**From:** [Jamey Ayling](#)  
**To:** [Zach Torrance-Smith](#)  
**Subject:** FW: CU-26-00001 Jentges Quiet Cadence  
**Date:** Tuesday, May 5, 2026 2:47:50 PM  
**Attachments:** [image001.png](#)  
[image002.png](#)  
[image003.png](#)  
[image004.png](#)

**From:** Jamey Ayling <[jamey.ayling@co.kittitas.wa.us](mailto:jamey.ayling@co.kittitas.wa.us)>  
**Sent:** Tuesday, May 5, 2026 2:36 PM  
**To:** Melissa Schumaier <[melissa.schumaier@co.kittitas.wa.us](mailto:melissa.schumaier@co.kittitas.wa.us)>  
**Subject:** CU-26-00001 Jentges Quiet Cadence

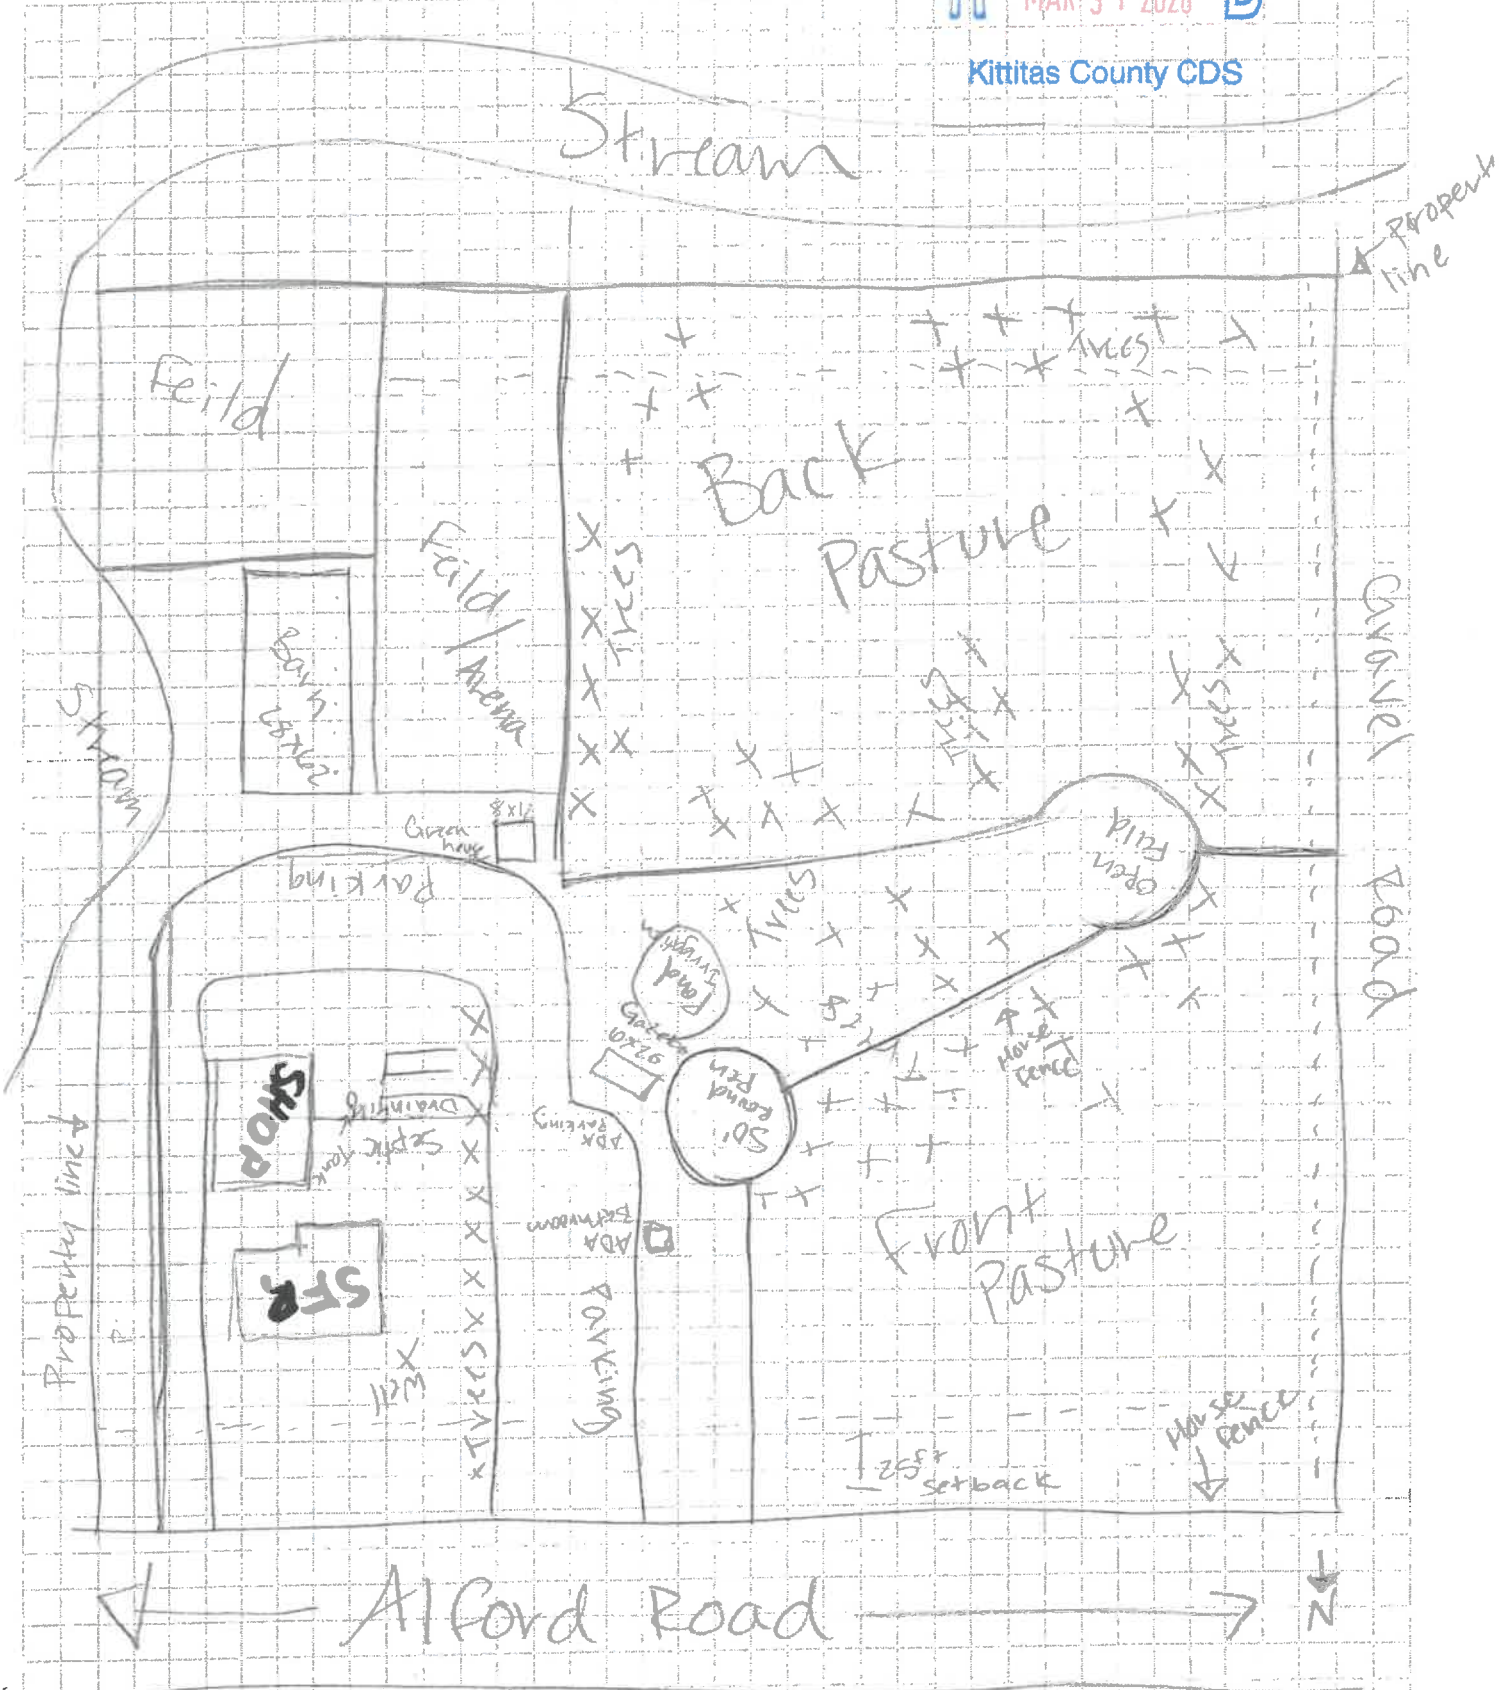
Melissa, thanks for letting me interrupt today, I reviewed the site plan for the CUP (CU-26-00001) compared to Pre-App (Pm-26-00002) when I got back to the office and can see the confusion. The bathroom is labeled as an ADA Bathroom but it is not a new building it is an ada accessible porta potty with an attached handwash station from Brown and Jackson this was not clear on the site plan. They are also not providing the clients with water other than bottled water from Costco. I think this will help to edit the Health Comments on the CUP to state if in the future they add a permanent restroom facility they would need to review the original septic design and upgrade the well to a group A system etc. let me know your thoughts. Thanks Jamey

I apologize for the added comments that were more than they need. If they choose to use the portable toilets and bottled water for their guests, this will meet their needs for the Public Health requirements. Please tell them to reach out if they ever choose to amend their plans and would like to have permanent fixtures on site.
